Application by Fenwick Solar Farm Ltd for an Order Granting Development Consent for Fenwick Solar Farm Project

The Examining Authority's first written questions and requests for information (ExQ1)

Issued on Friday 9 May 2025

1:10,000 @ A3

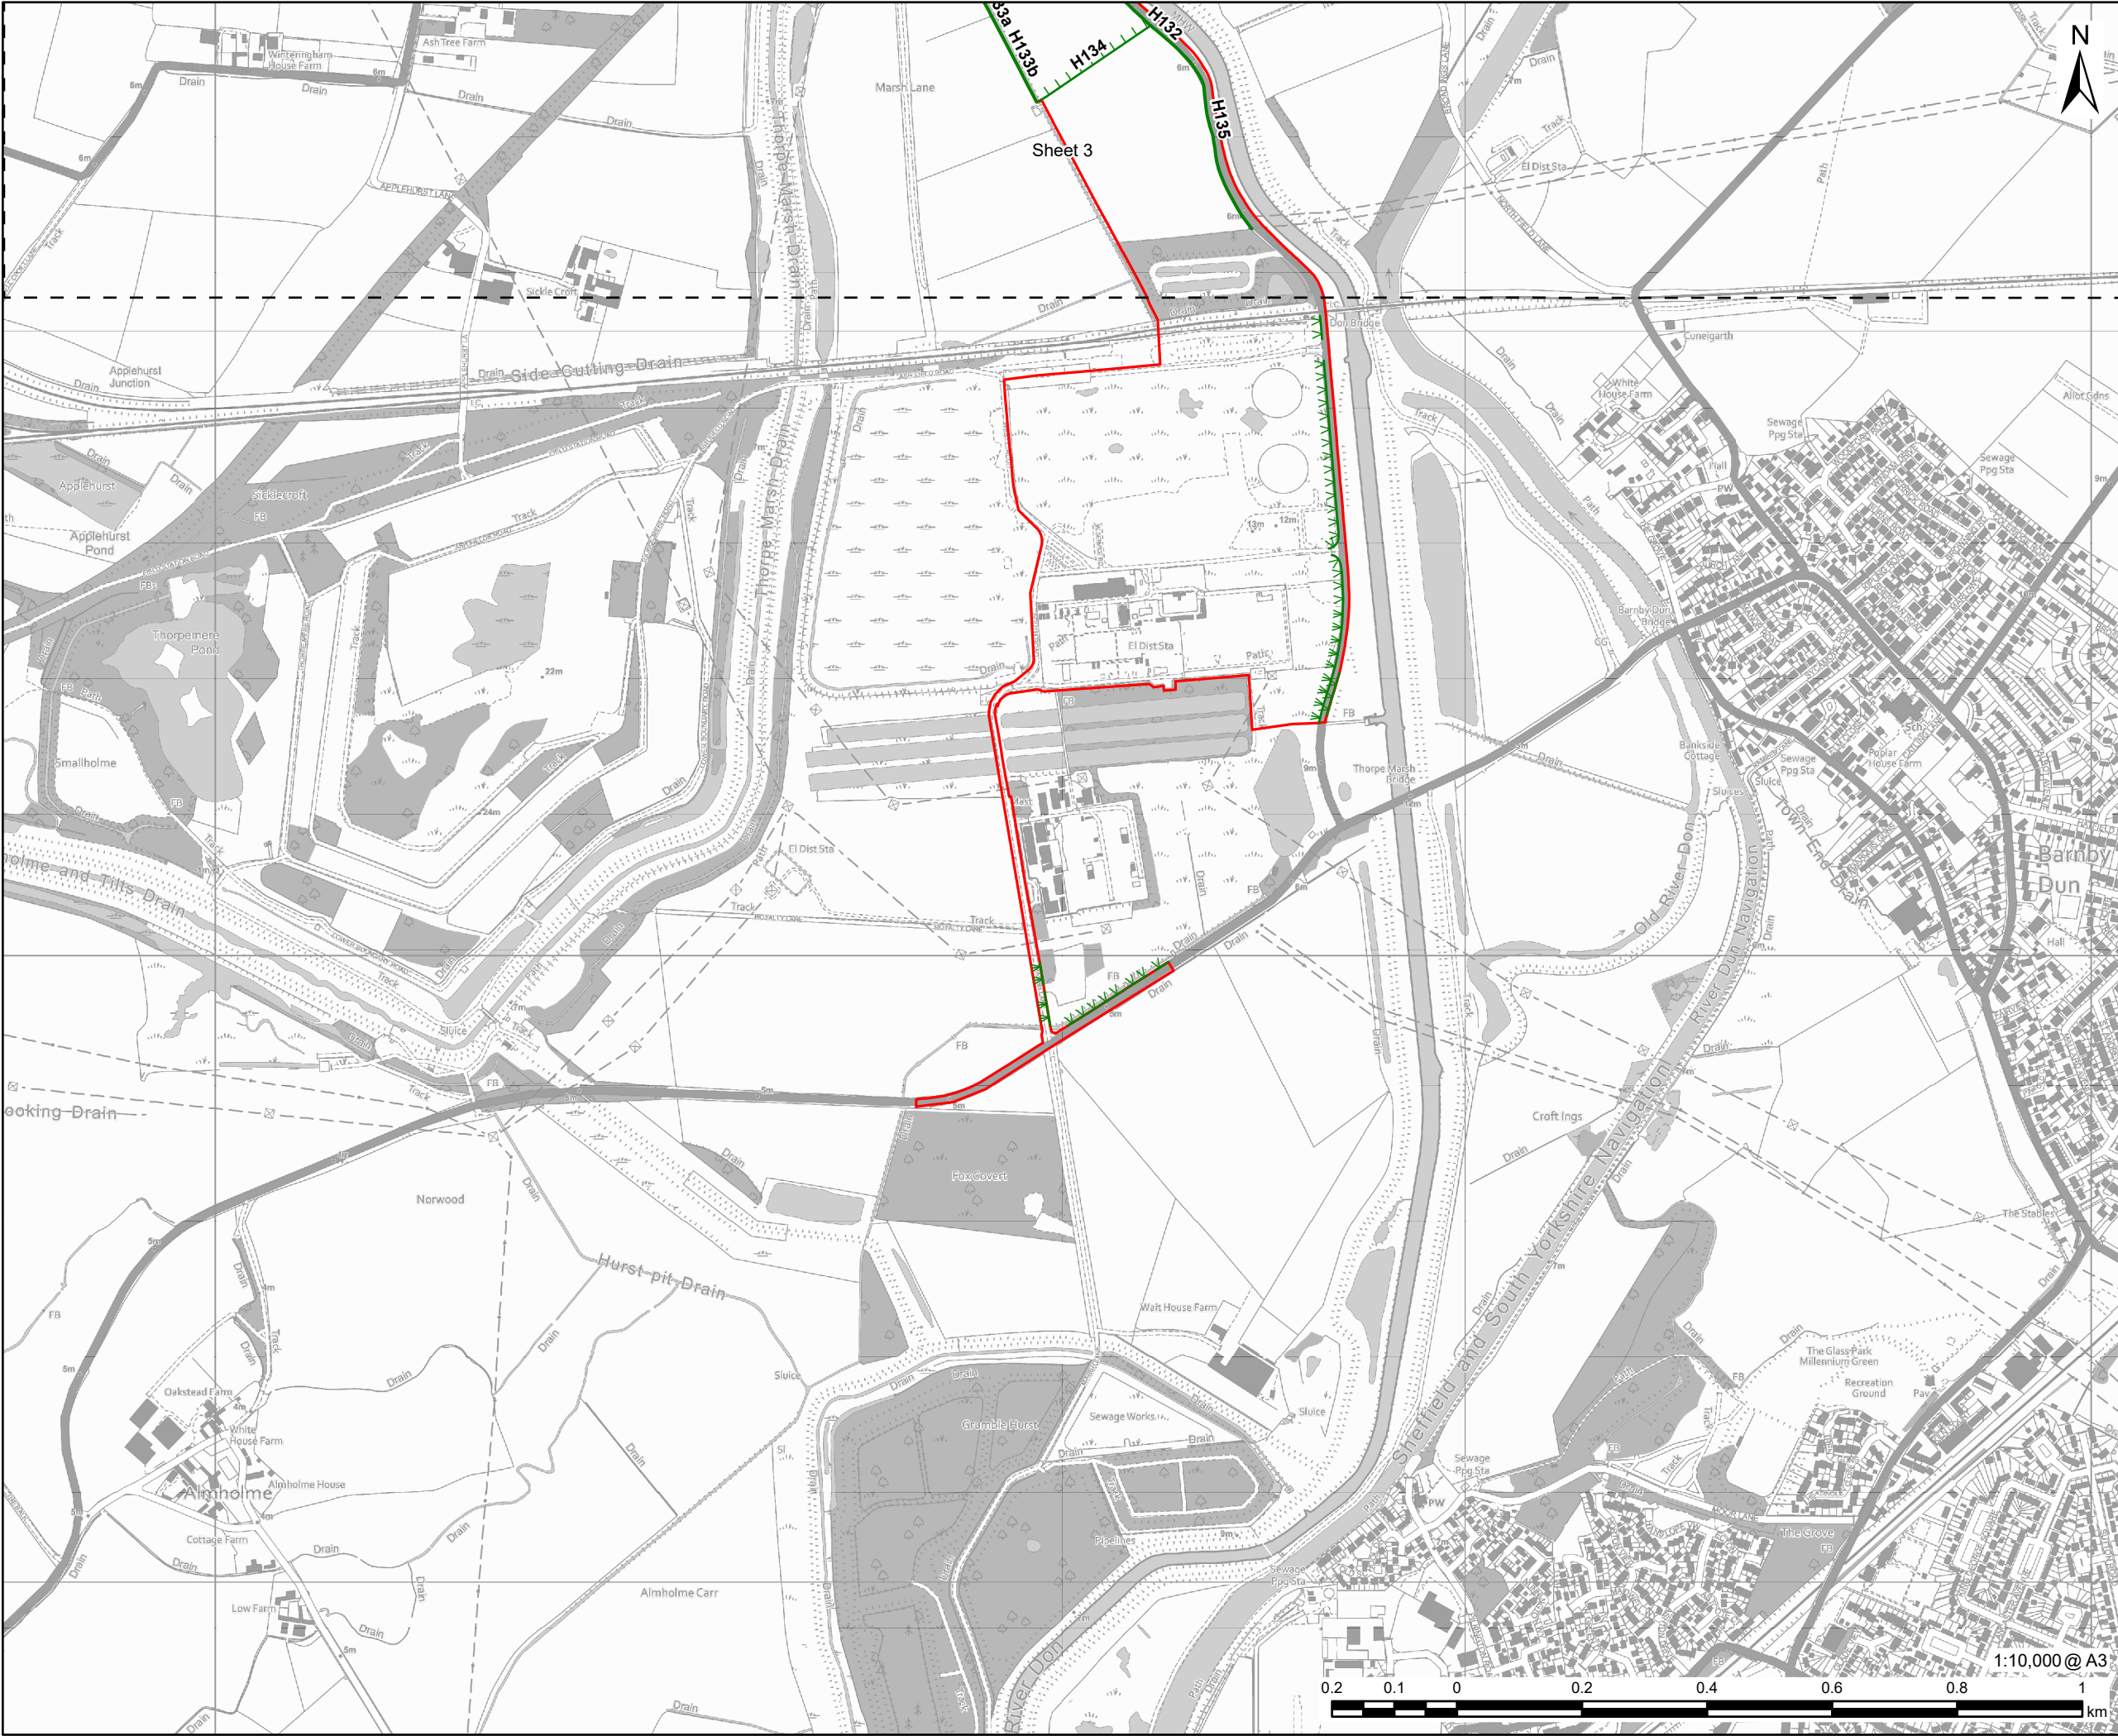
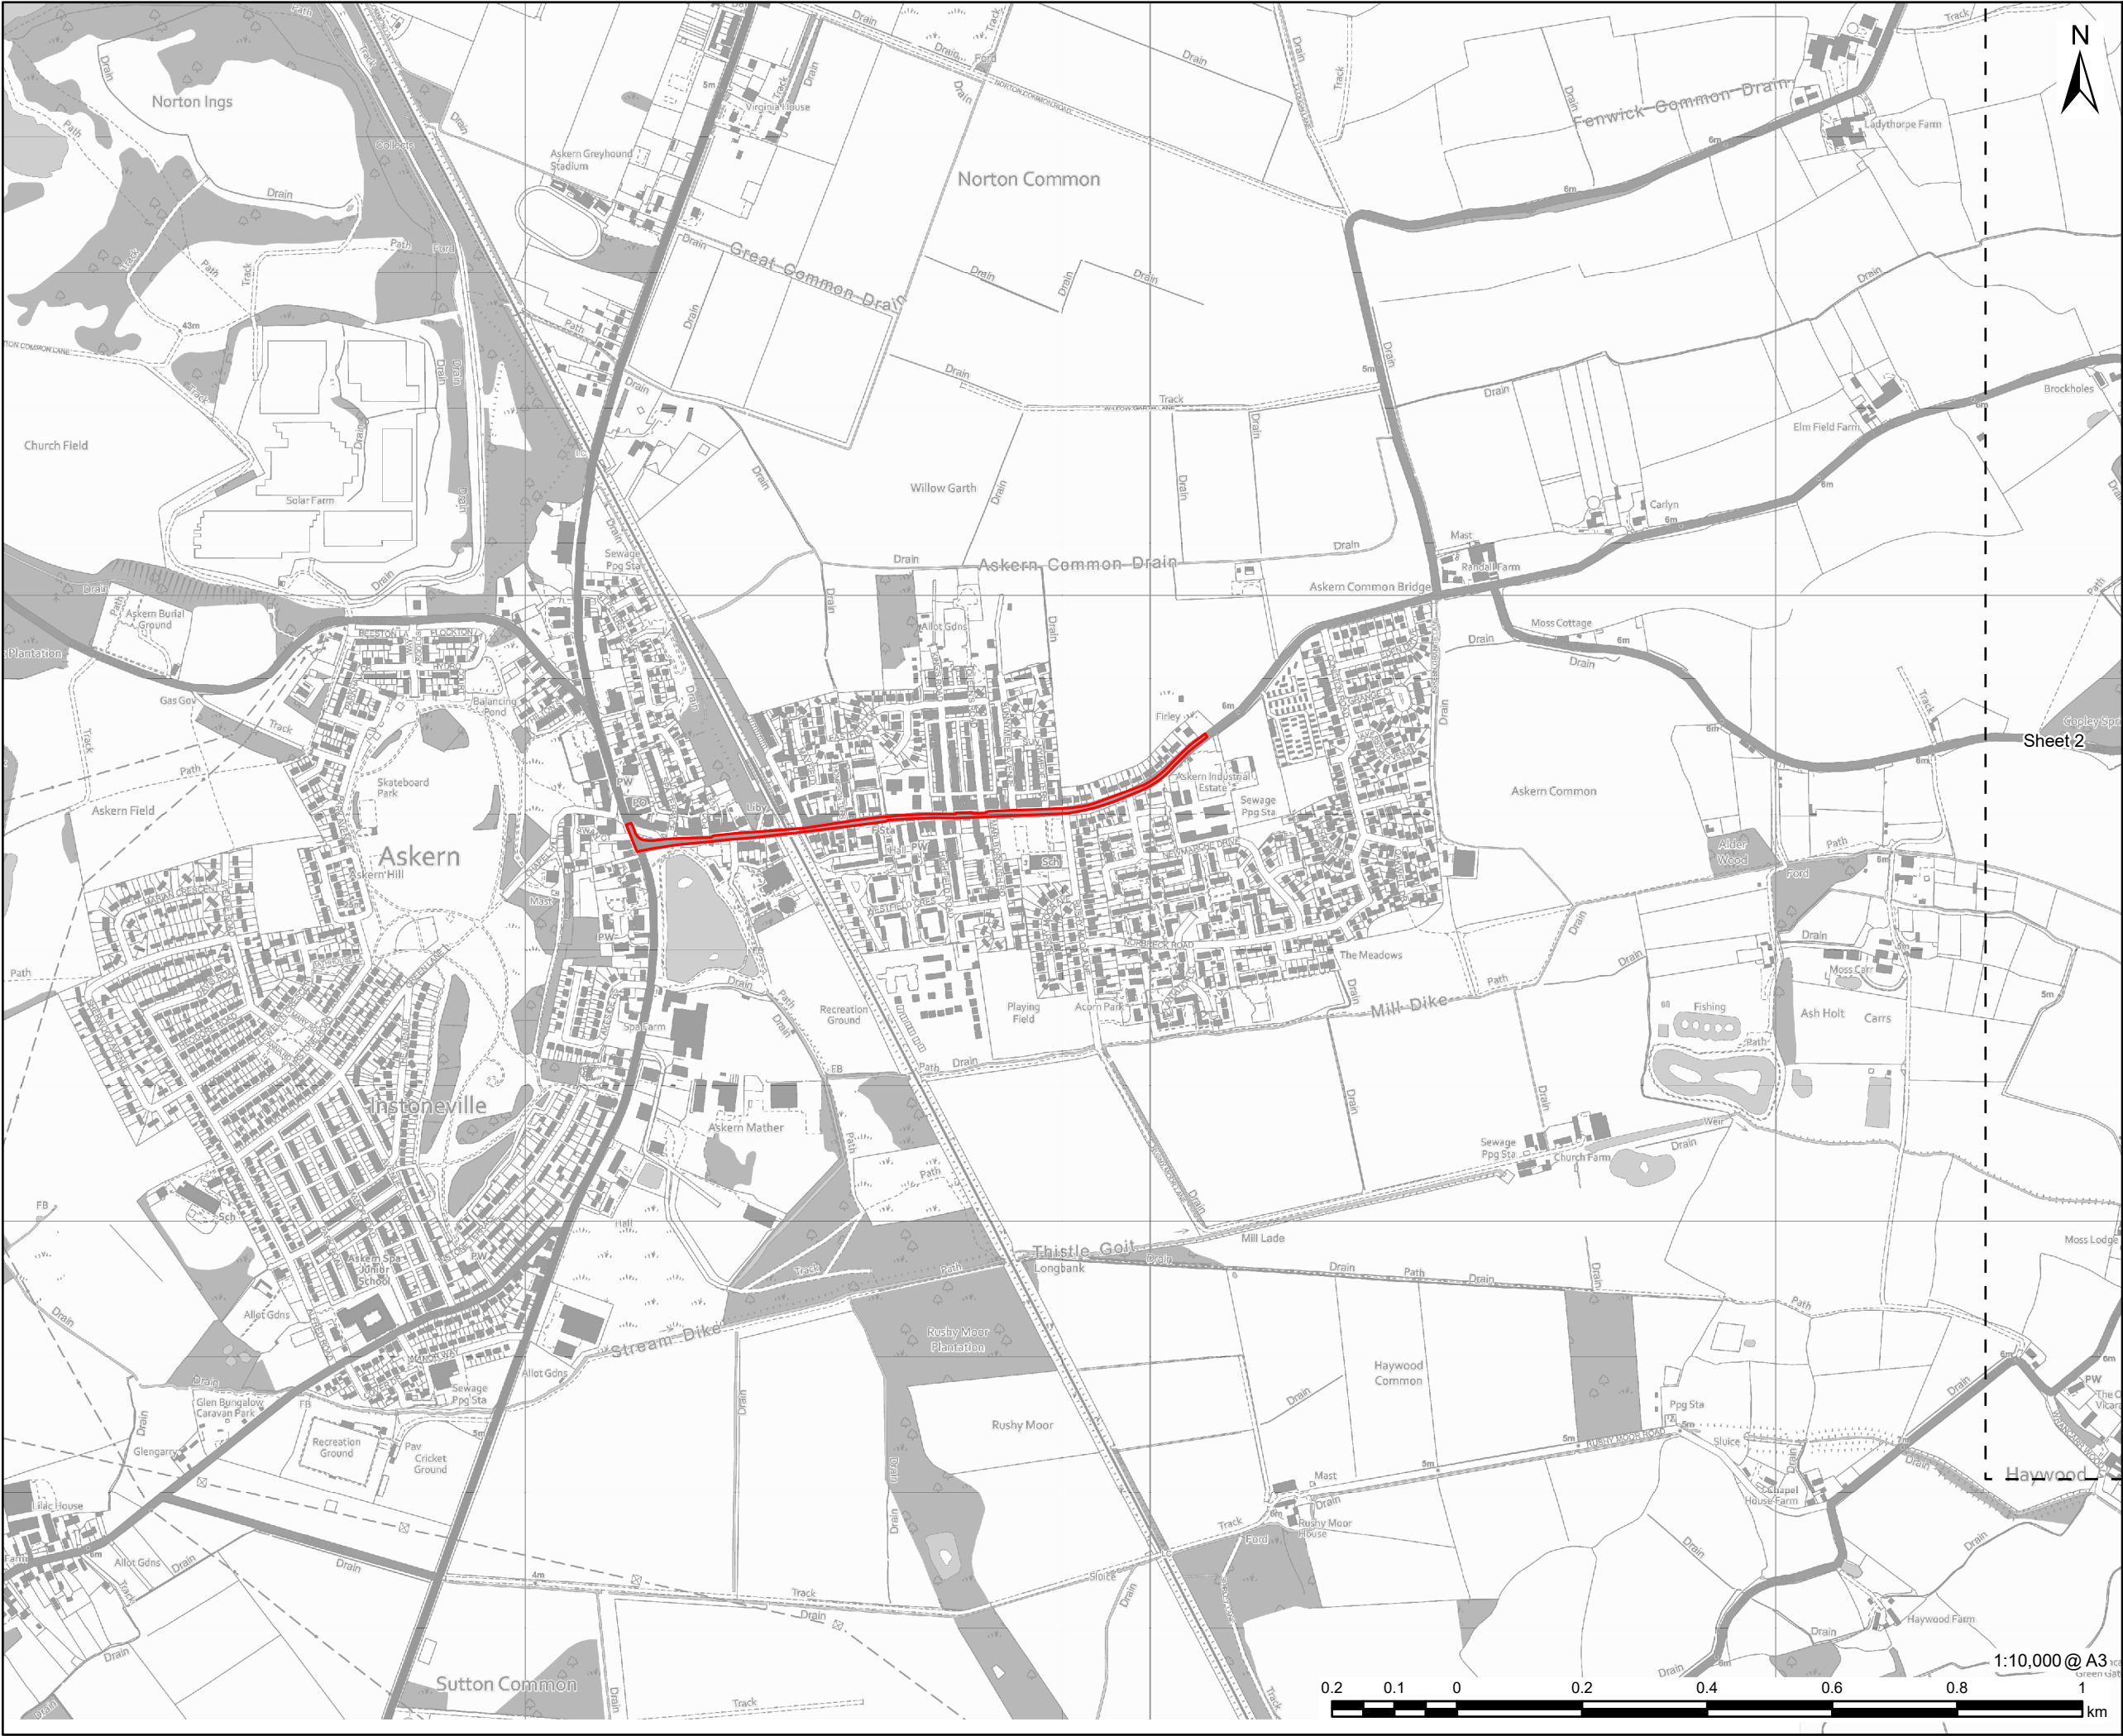
1.6.11	Applicant	Hedgerow Report [APP-150] Figure 8-5-1. Hedgerow H83 and H96 run alongside footpath Fenwick 16 (Haggs Lane). Haggs Lane is identified as the inbound access route for construction workers. Please signpost where within this report or the ES protection measures are proposed for these hedgerows during the construction phase given the need to accommodate both traffic and rights of way users along Fenwick 16.
